Ribble Valley Borough Council  
Council Offices  
Church Walk,  
Clitheroe  
Lancashire  
BB7 2RA

Phone: 0300 123 6780  
Email: [developeras@lancashire.gov.uk](mailto:developeras@lancashire.gov.uk)  
Your ref: 3/2026/0217  
Our ref: 3/2026/0217/HDC/KW  
Date: 30 April 2026

**Location:** Thornley Hall Farm Up Bedlam Road Thornley PR3 2TN  
**Proposal:** Reserved matters application relating to appearance, landscaping, layout and scale following outline planning permission 3/2025/0289.  
**Grid Ref:** 363424 441074

**Title:** Proposed Site Plan  
**Drawing No:** Air/1164/3803 - 03 **Drawn:** MP  
**Client:** G.E. Airey & Sons  
**Date:** 18.03.2026 **Scale:** 1:200 @ A1  
**Amendments:**

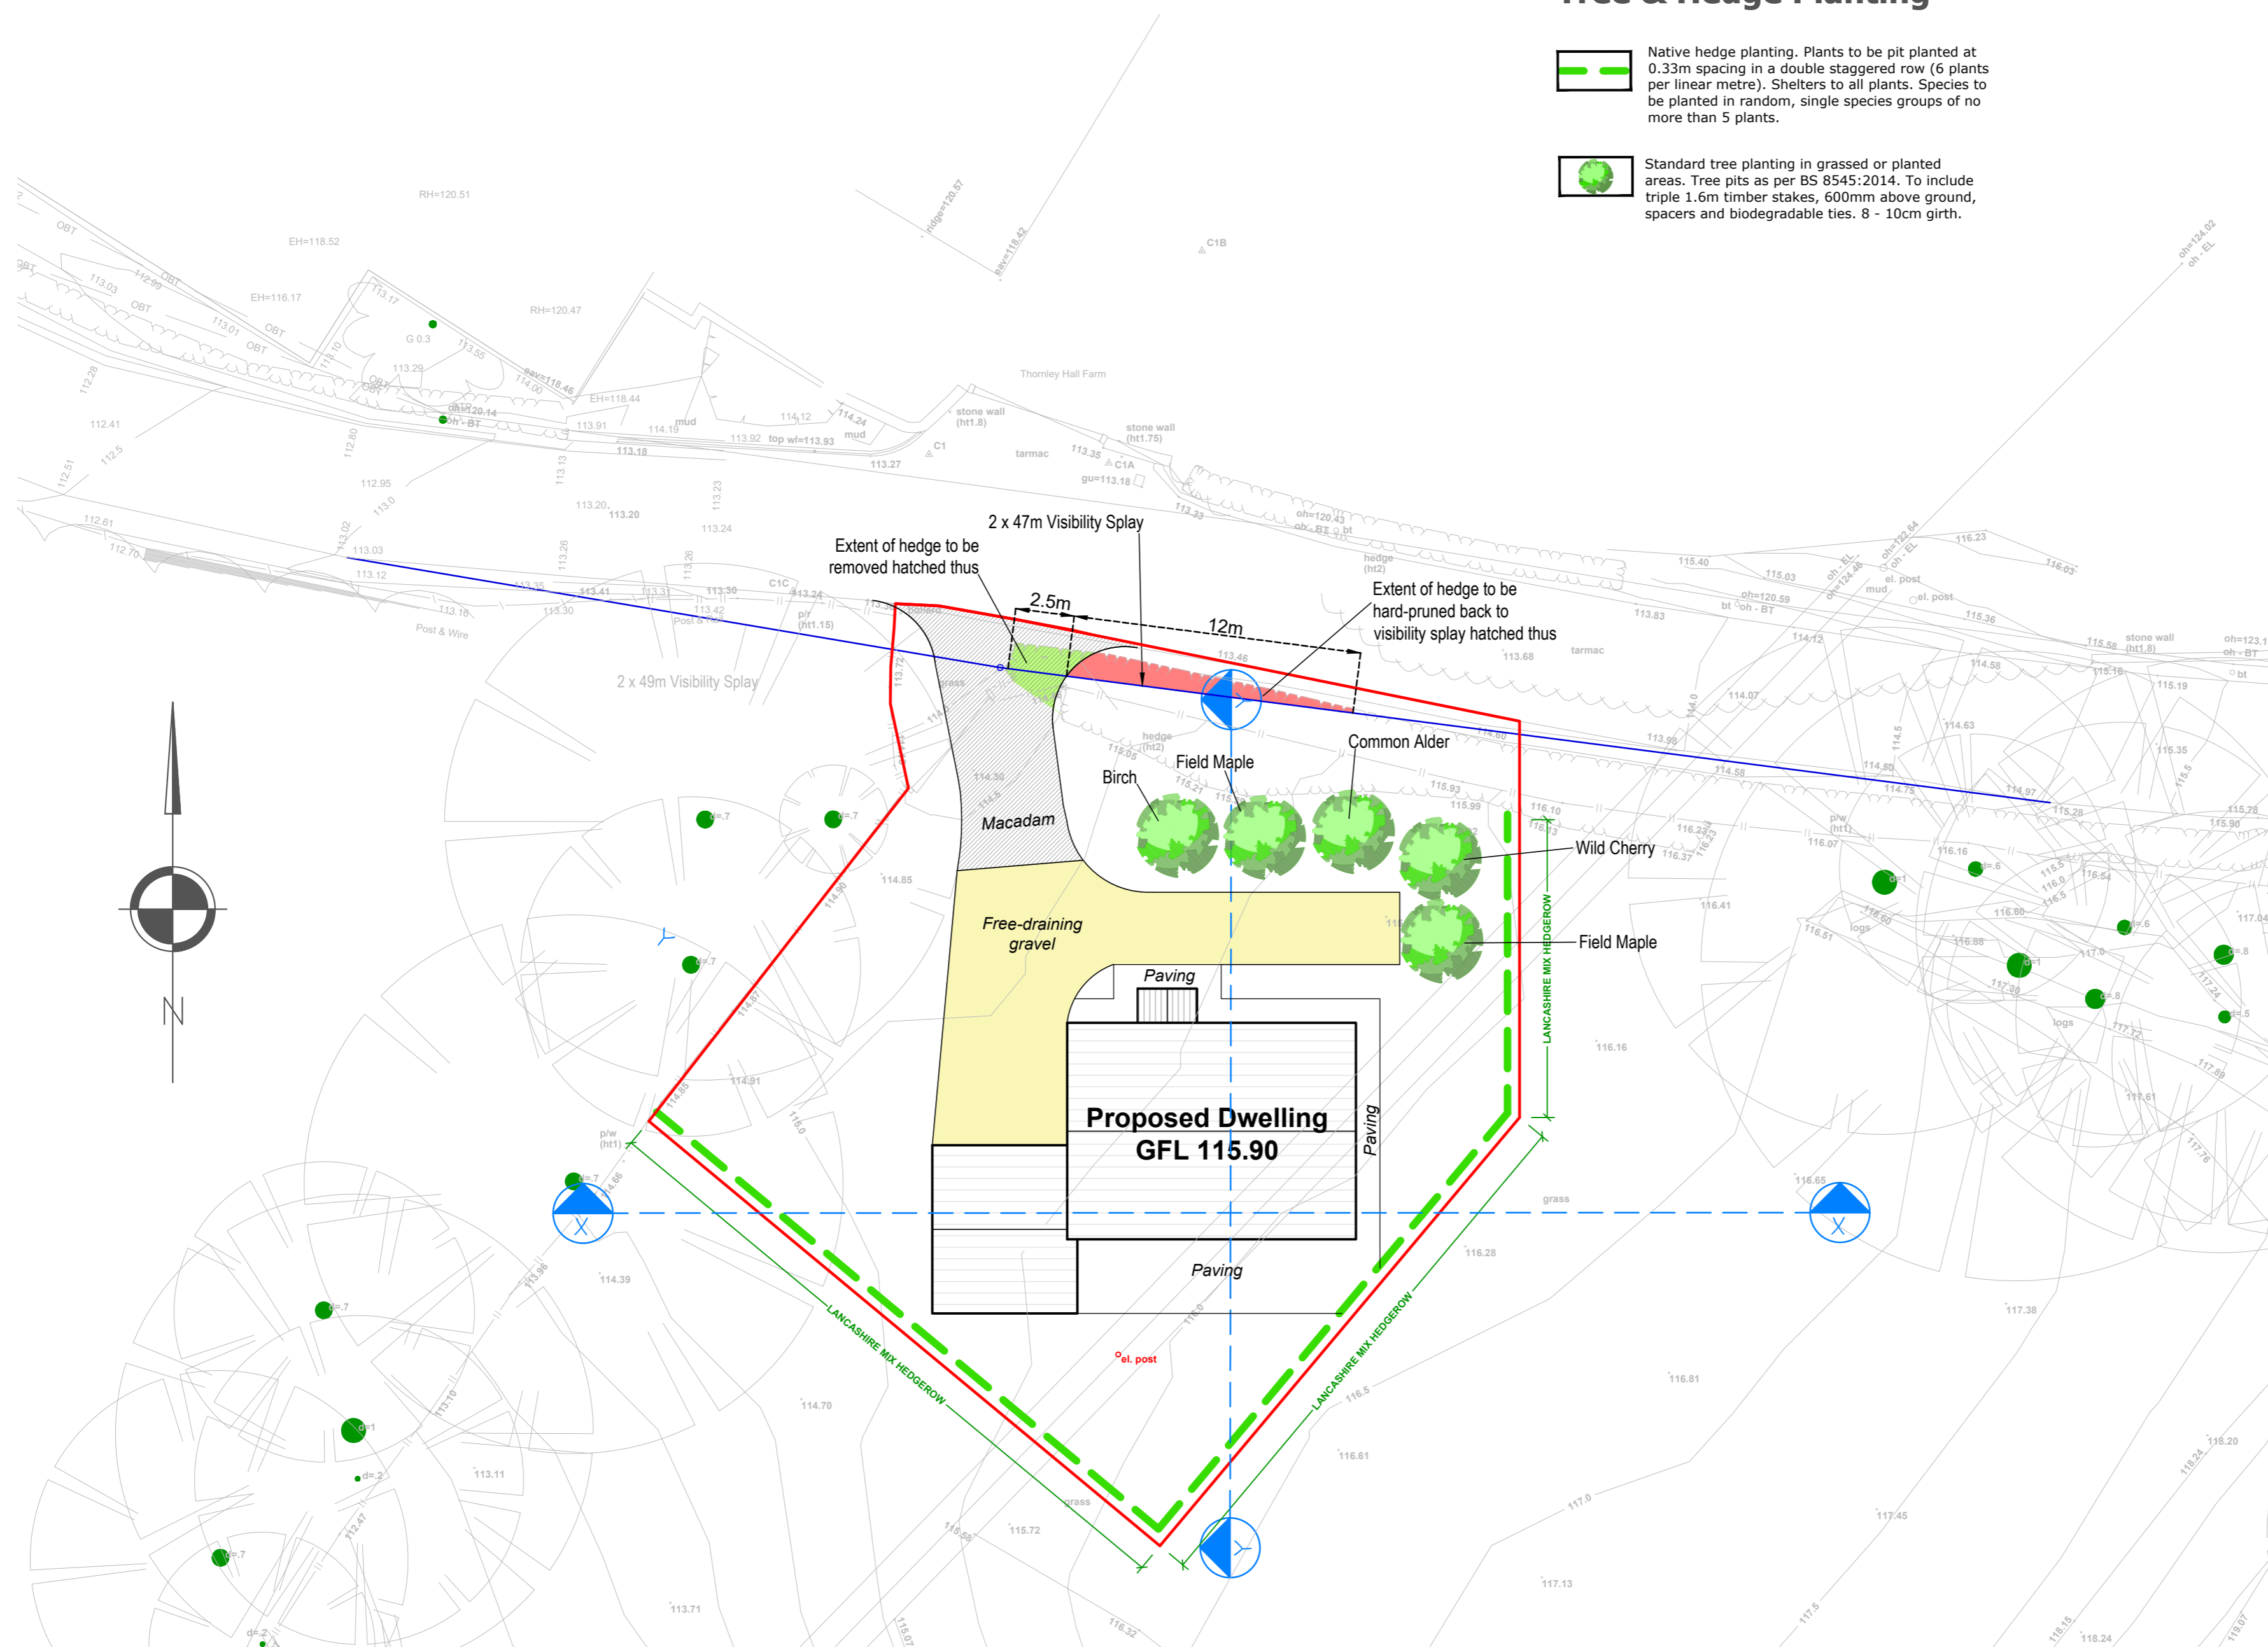
The LHA has viewed the parking and turning provisions within, drawing Air/1164/3803 – 03, which comply with the LHAs parking standards as defined in the Joint Lancashire Structure Plan. The turning provisions within the site will enable ingress and egress in forward gear.

2. No part of the development hereby permitted shall be occupied until such time as the access arrangements shown on drawing number Air/1164/3803 – 03 have been implemented in full.  
**Reason:** To ensure that vehicles entering and leaving the site may pass each other clear of the highway, in a slow and controlled manner, in the interests of general highway safety and in accordance with the National Planning Policy Framework.
